WEST SUSSEX COUNTY COUNCIL CONSULTATION

TO:	Arun District Council - FAO:Anita Gardner
FROM:	WSCC - Highways Authority
DATE:	12 January 2022
LOCATION:	Land rear of Paynters Croft Burndell Road Arundel BN18 0HR
SUBJECT:	F/22/21/PL 23 No dwellings with associated access, infrastructure, landscape and open space (resubmission following F/5/21/PL). This application is a Departure from the Development Plan & is in CIL Zone 3 and is CIL Liable as new dwellings. More information received.
RECOMMENDATION:	No Objection

Drawing Status	FINAL						
Client	Driftstone Homes						
Project	Burndell Road, Yapton						
Drawing Title	Proposed Access Road Overview and Dimensions						
Scale	As Shown	Date	Sept 20	Drawn By	SMO	Checked By	ALB
Drawing No.	2020-6145-002				Rev.	I

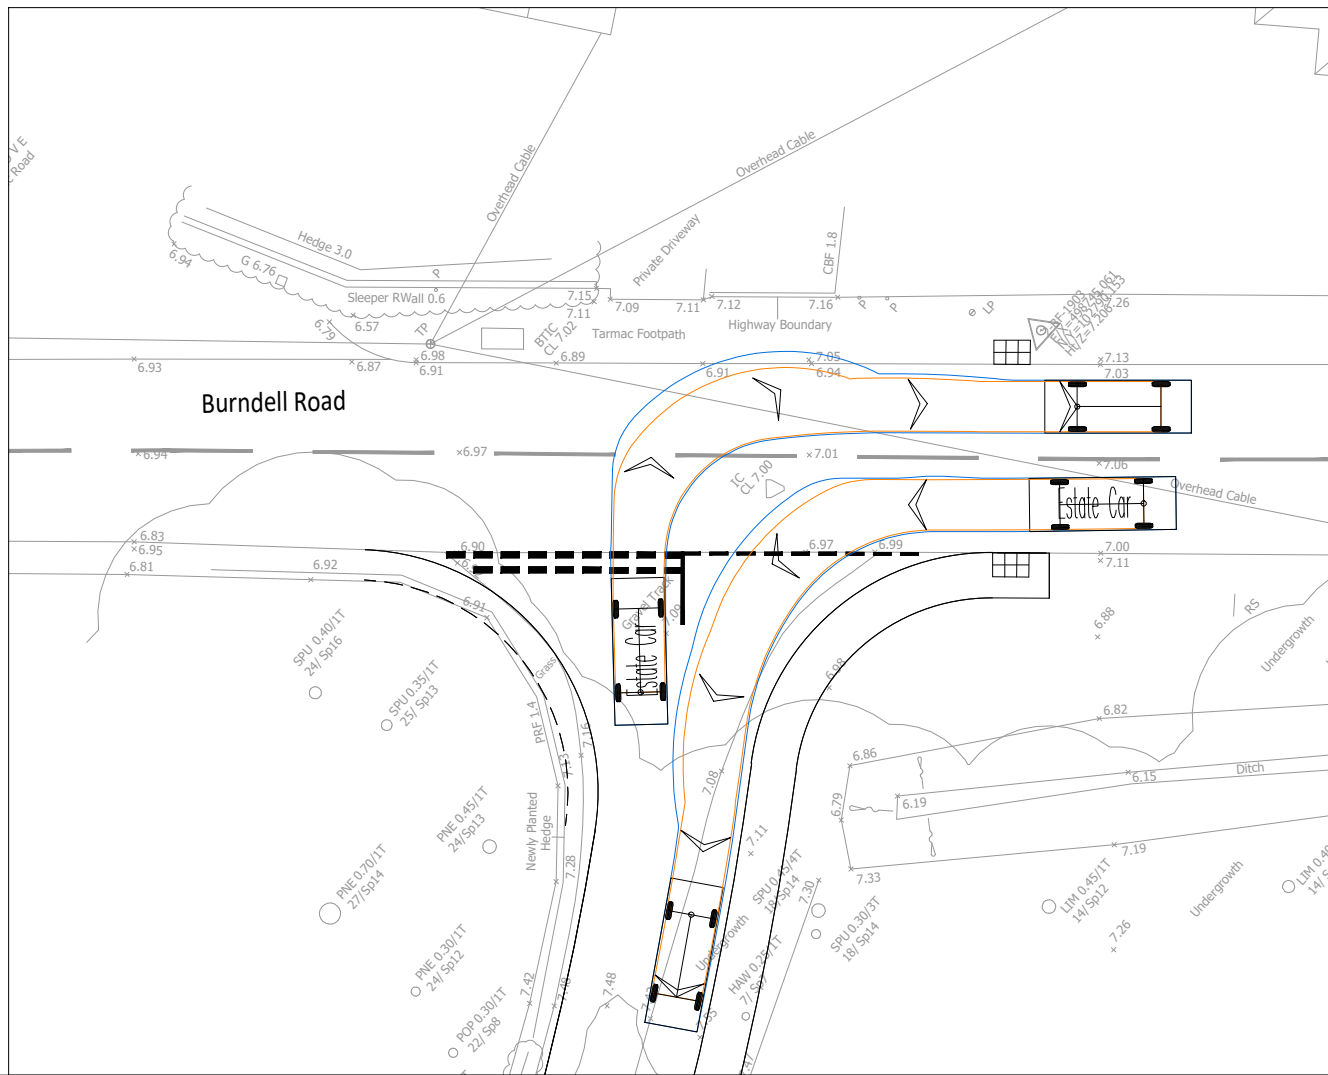
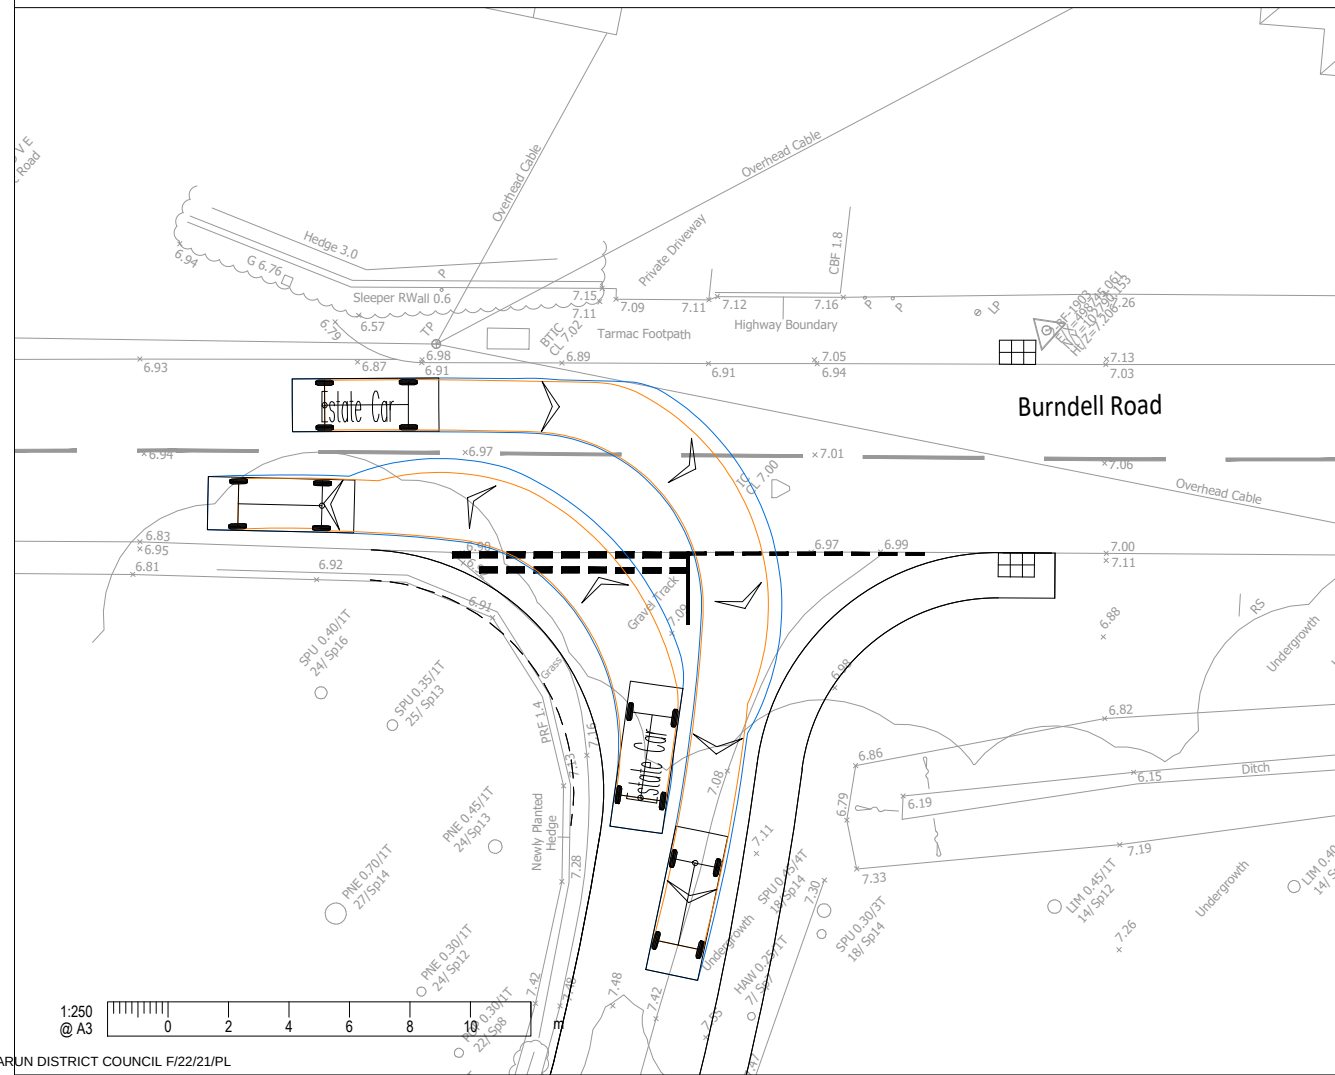
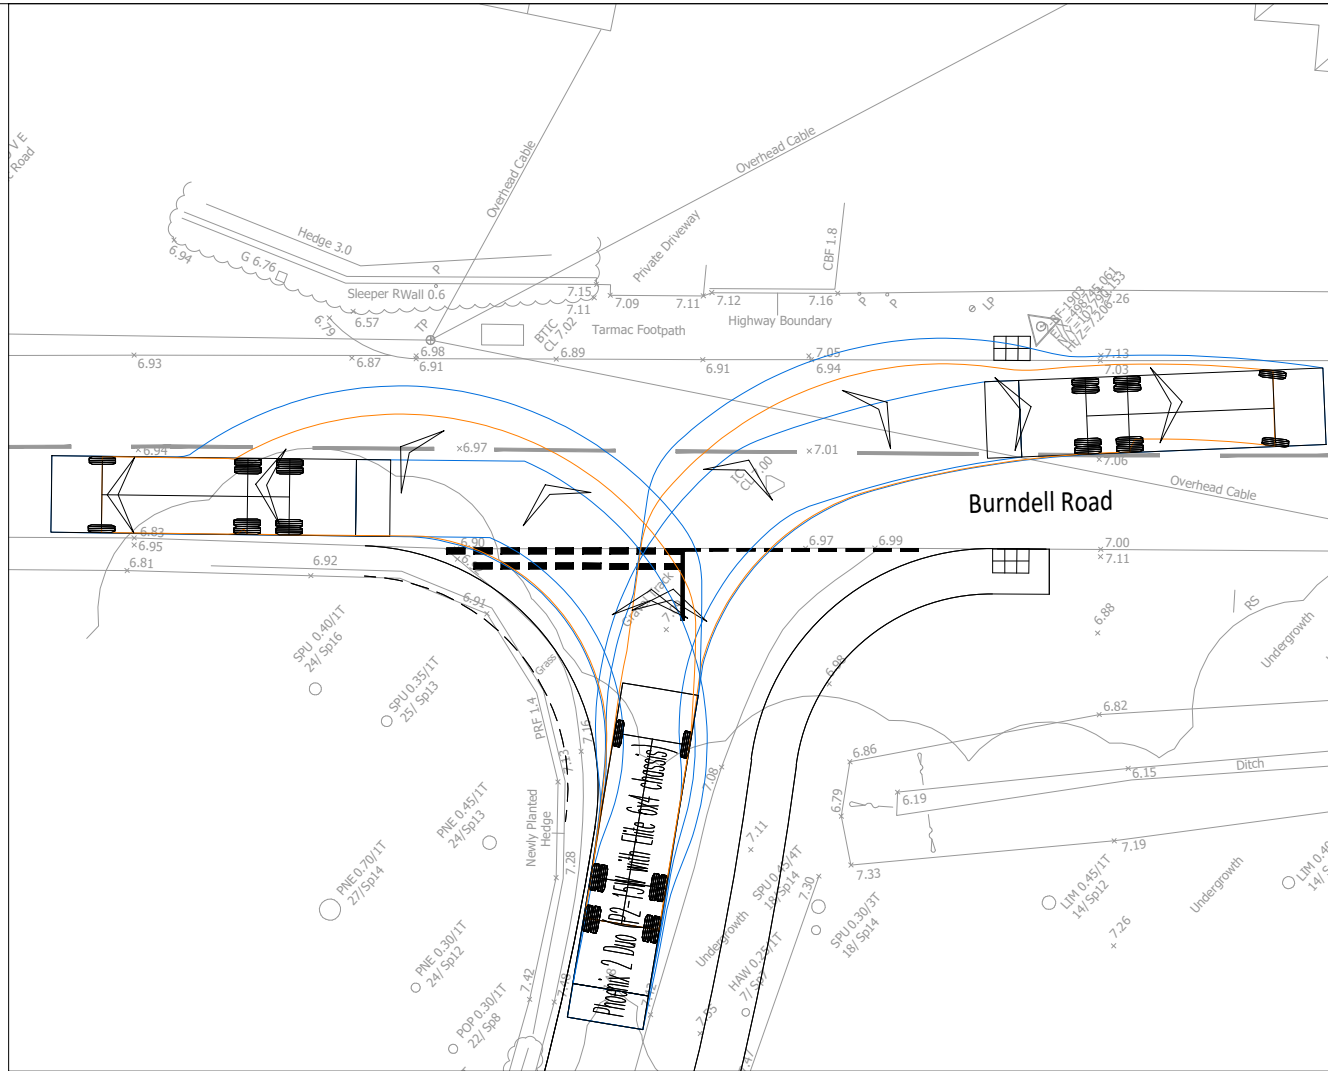
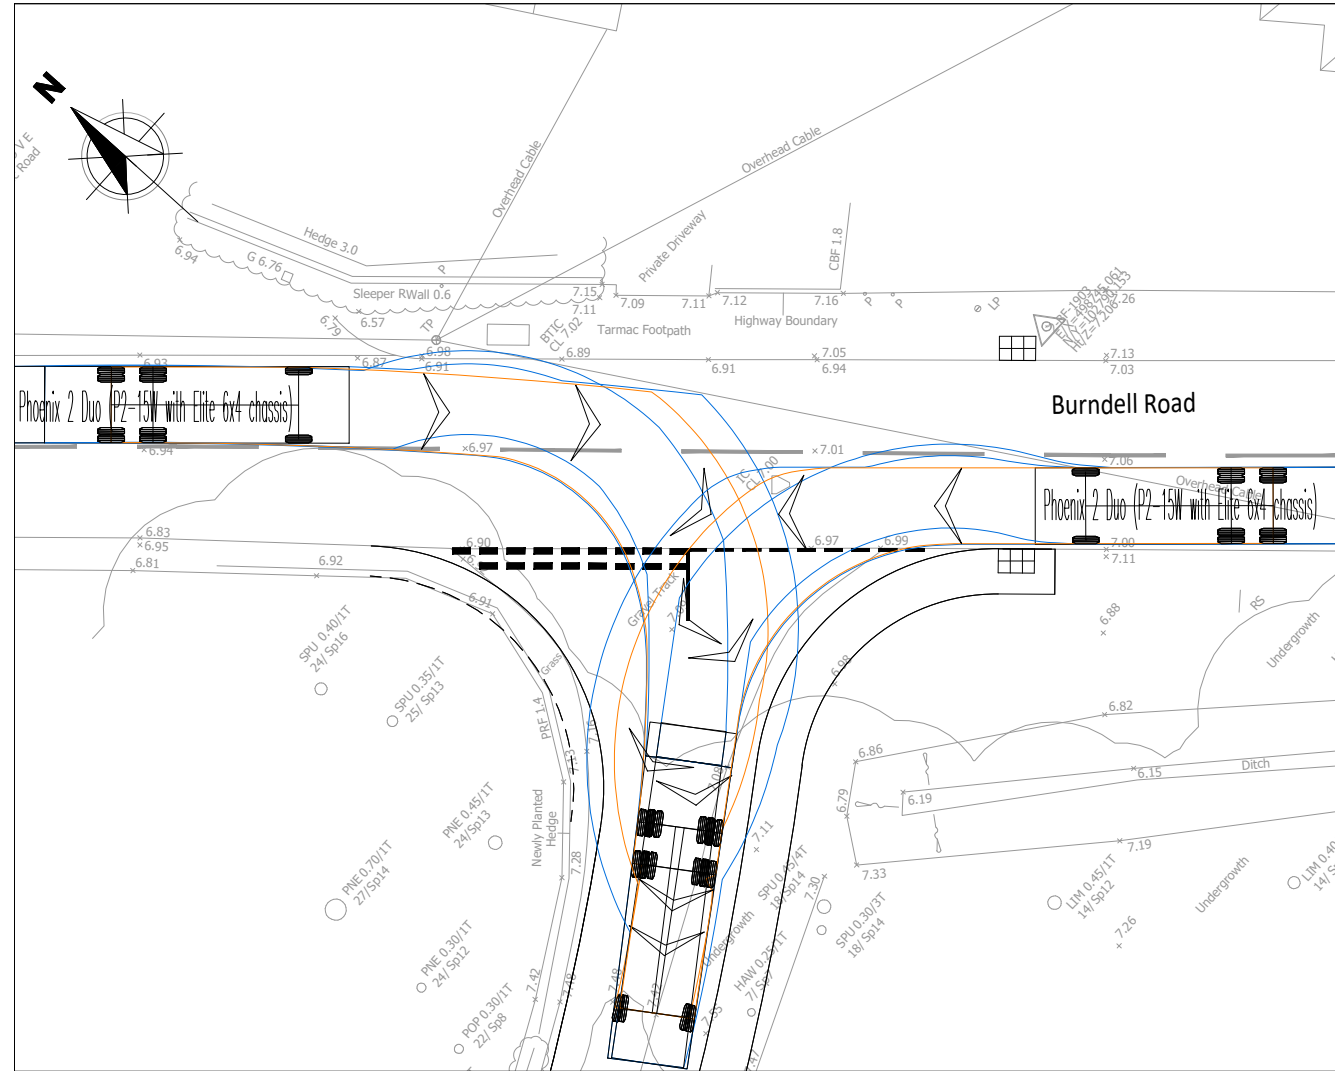
- Show splays of 2.4m by 58m south and 60m north can be accommodated without passing through third party land.
- Clearly show extent of footway from access road past plots 1 and 2.
- Ensure single garages of 3m width.

Drawing no. 2020-6145-002 Rev I (Proposed Access Road Overview and Dimensions) shows the correct access road footway arrangement and the Site Overview plan confirms that the footway will continue past plot 1 and 2 within the site.

Drawing Status	FINAL		
Client	Driftstone Homes		
Project	Burdell Road, Yapton		
Drawing Title	Access Overview and Visibility Splays		
Scale	1:250	Date	July 21
Drawn By	SMO	Checked By	ALB
Drawing No.	2020-6145-001		Rev.
		I

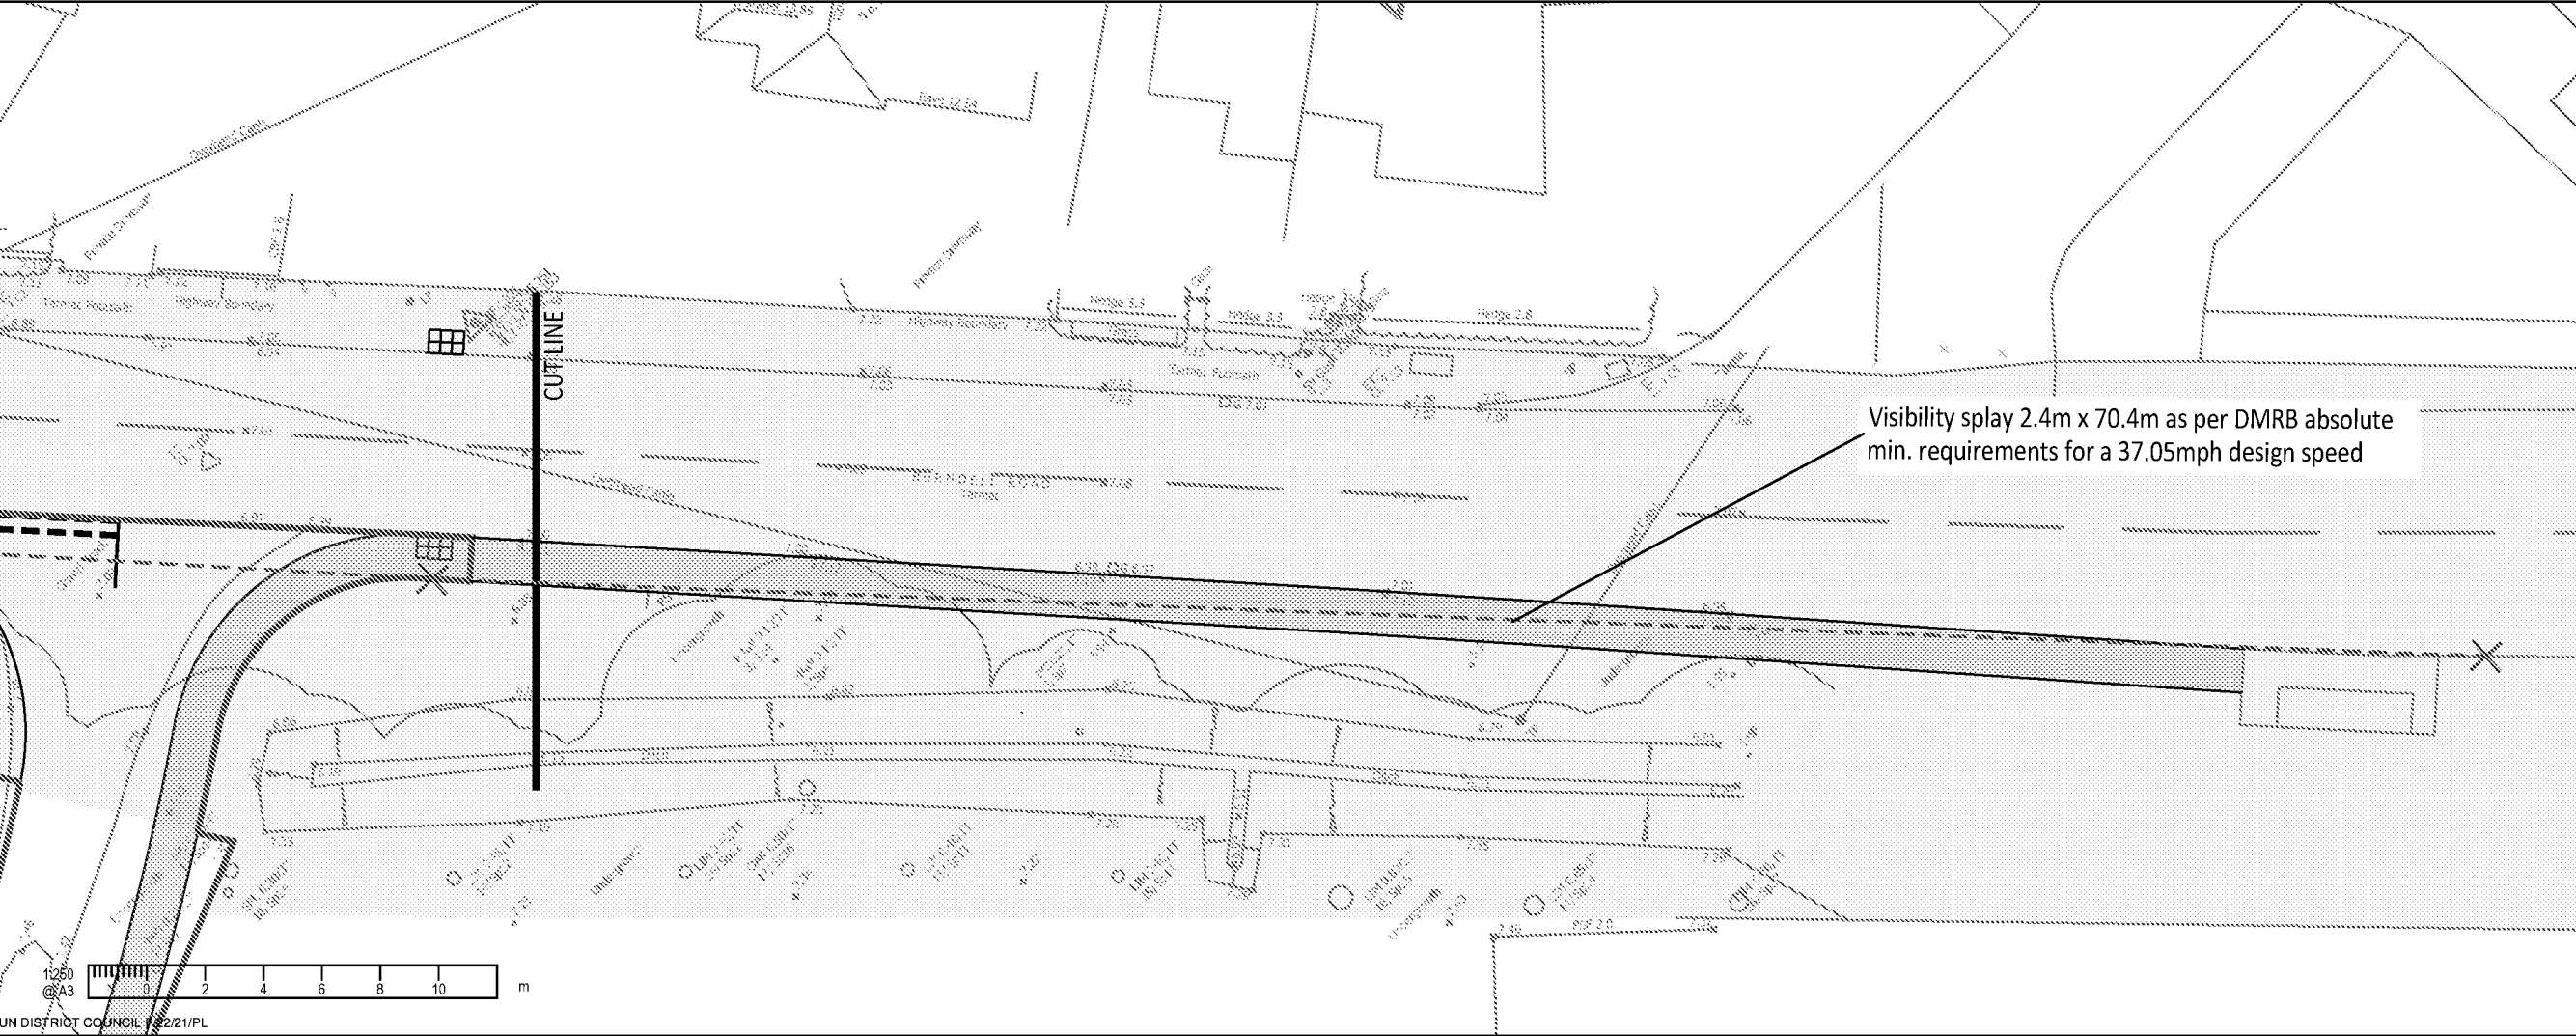
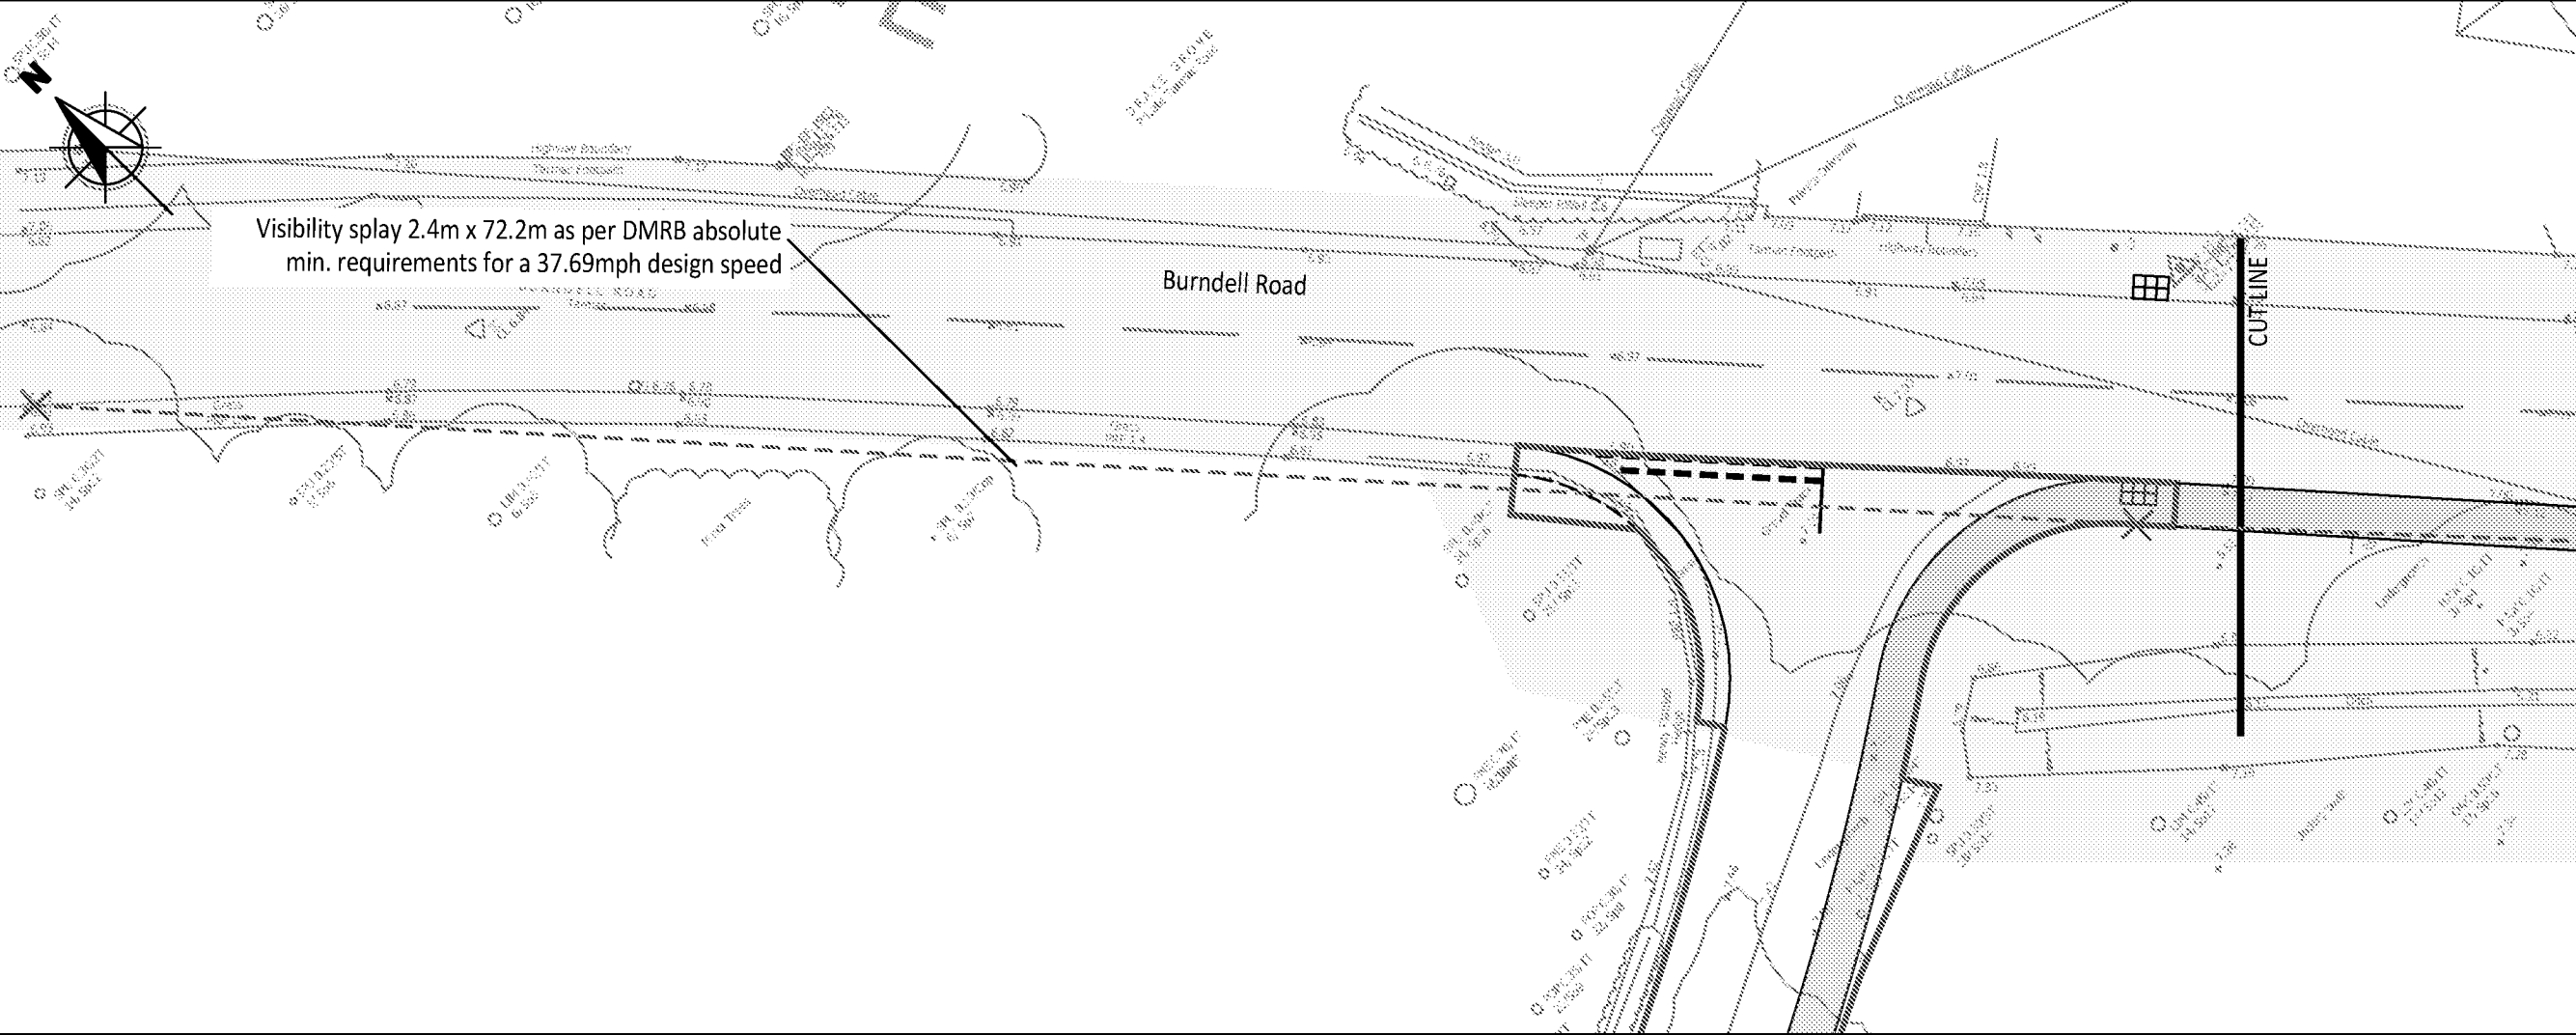
Drawing no. 2020-6145-001 Rev J (Access Overview and Visibility Splays) shows 2.4m by 58m south (entirely within adopted highway land) and 2.4m by 60m north within adopted highway land and red edge of site. The Local Planning Authority (LPA) should be satisfied that red edge shown is land within applicants control, in order to maintain the splays in perpetuity.
